Reinforcement to the North Shropshire Electricity Distribution Network

SP Manweb's Responses to S51 Advice and Comments on the S55 Checklist

Application Reference: EN020021

Scale: 1:2,500@A1	Date: November 2018	
Drawing No: Sheet 1 of 16	Revision: v6.0	
Approved By: SAN	Checked By: NTR	Drawn By: RGU

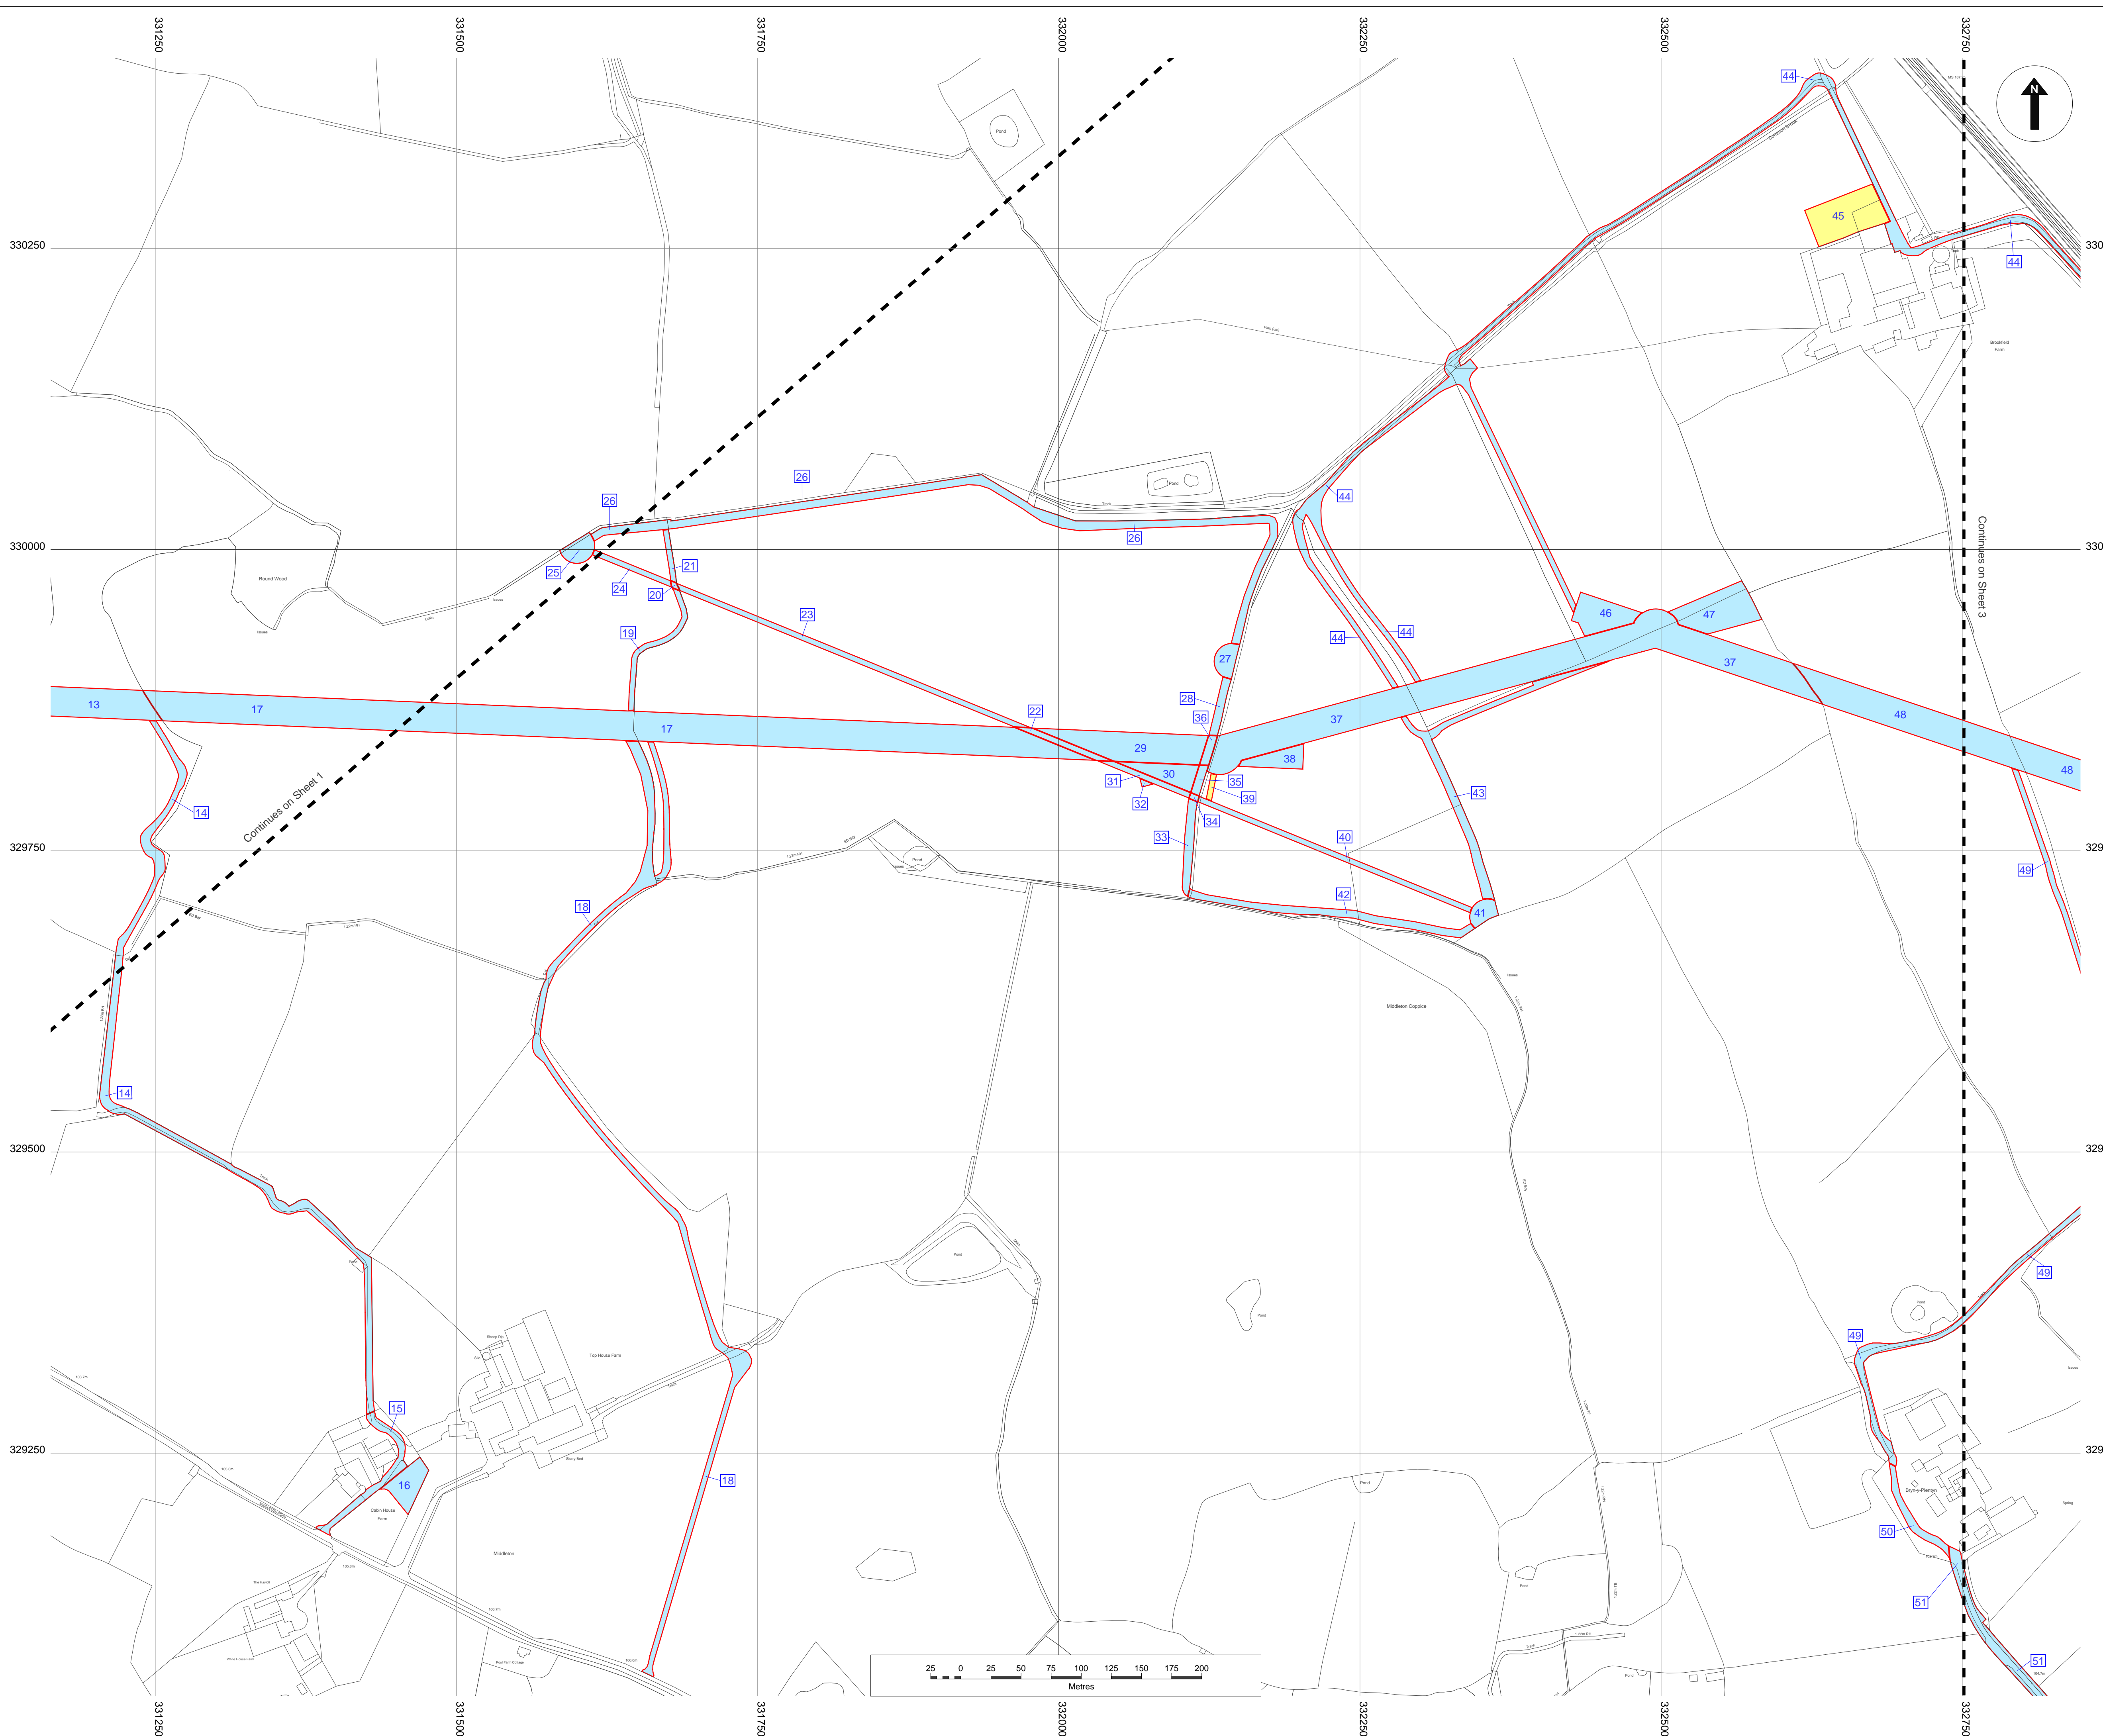
Examining Authority’s Comment
<p>The plots coloured yellow on the Land Plans are described in the legend as “<i>Order Land – temporary rights (construction only) to be compulsorily acquired, and temporary use of the land, and in relation to which it is proposed to suspend or extinguish easements, servitudes and other private rights</i>”. It is not clear from this whether it is temporary possession or compulsory acquisition of permanent rights to be used temporarily which is intended by the Applicant in relation to specific plots.</p> <p>Some discrepancies were found between the colour of some plots on the Land Plans and the description of rights the Applicant is seeking over that land in the Book of Reference. The Applicant is advised to carry out a full review of the Land Plans and the Book of Reference and ensure that all land interests are clearly informed about the precise nature of rights the Applicant is seeking over their land.</p>

- 2.16. Sheet 1 of the Land Plans shows Plots 9 and 11 correctly coloured yellow. However, the Book of Reference should not have referred to Class 5 rights in respect of these two Plots. The Book of Reference and the Statement of Reasons will be amended to remove reference to Class 5 rights for these two Plots.
